**WEST SUSSEX COUNTY COUNCIL
STRATEGIC PLANNING CONSULTATION**

SUBJECT: P/84/12

New access road & amendment to curtilage of Plot 1 - amendment to approval P/44/09 (resubmission following refusal P/30/12).

Car Park Land Off, 1, Sandy Road, Pagham, West Sussex, PO21 4SP

PLAN NO 598/10B  
SCALE 1:200  
DATE 03/09

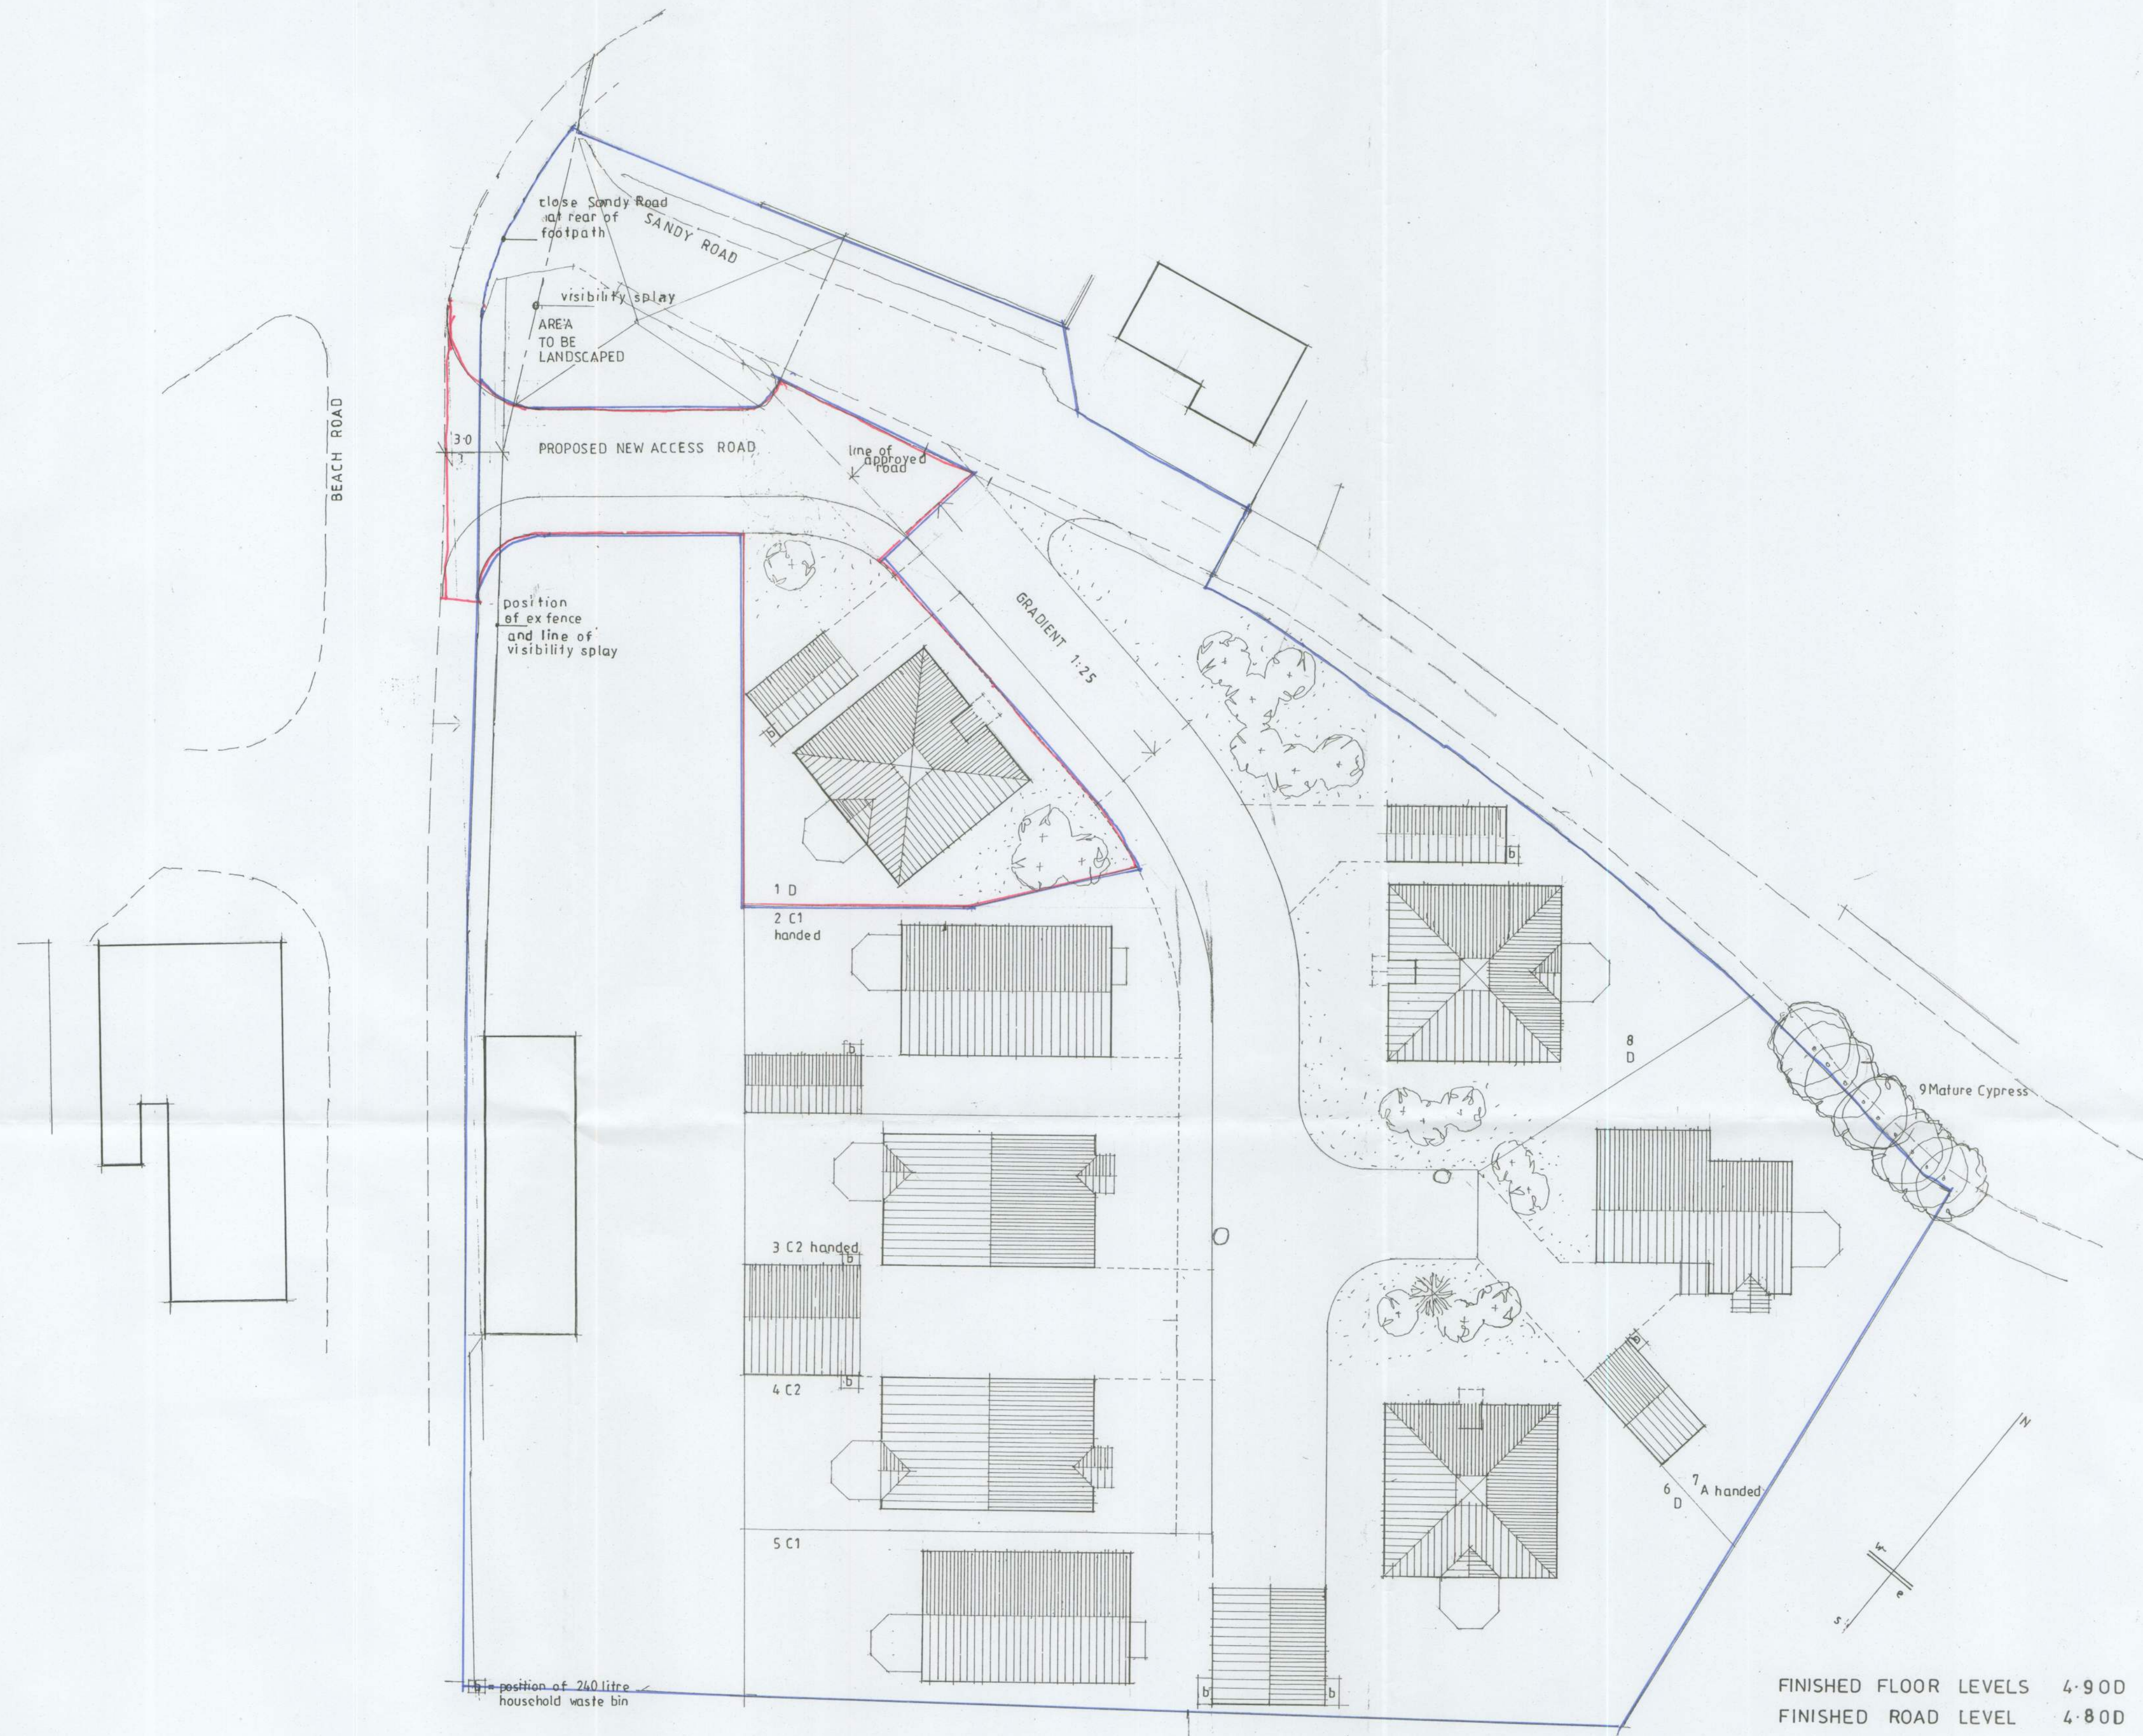
Whilst the 'New Access' is opposite what appears to be a roundabout arrangement, it is noted that give way lines onto Beach Road results in the arrangement operating as a priority junction. It is noted that visibility to the south is very good although to the north it is limited by the proximity to the junction. Although speed counts to the south of the point of access have indicated an 85th percentile speed of approx 25mph, it is considered that at the give way point of the junctions to the north that vehicle speeds will be much slower or stationary. Visibility can be achieved across both The Parade and Sea Lane give ways. There is unlikely to be interaction between the 'New Access' and the access opposite the junction, as well as very limited movement from a northerly direction off Beach Road. The majority of movements in and out of the junction are likely to be either left in or right out.

Any planting within the visibility splays should be kept to a maximum height of 600mm.

On balance, it is considered that the closing of Sandy Lane with movements routed via New Access will provide an improvement to the current situation and would accord with guidance set out in Manual for Streets.

No part of the development approved under reference P/44/09 shall be first occupied until such time as the vehicular access serving the development has been constructed in accordance with the approved drawing 598/11.

No part of the development approved under P/44/09 shall be first occupied until such time as the existing vehicular access onto The Parade has been physically closed in accordance with the approved drawing 598/11.

No part of the development shall be first occupied until visibility have been provided in accordance with plans and details submitted to and approved in writing by the Local Planning Authority based on the approved access drawing 598/11. Once provided the splays shall thereafter be maintained and kept free of all obstructions over a height of 0.6 metre above adjoining carriageway level or as otherwise agreed.

No part of the development shall be first occupied until pedestrian visibility splays of 2 metres by 2 metres have been provided either side of the proposed site vehicular access onto Beach Road in accordance with plans and details submitted to and approved in writing by the Local Planning Authority. These visibility splays shall thereafter be kept free of all obstructions over a height of 0.6 metre above adjoining carriageway level or as otherwise agreed.
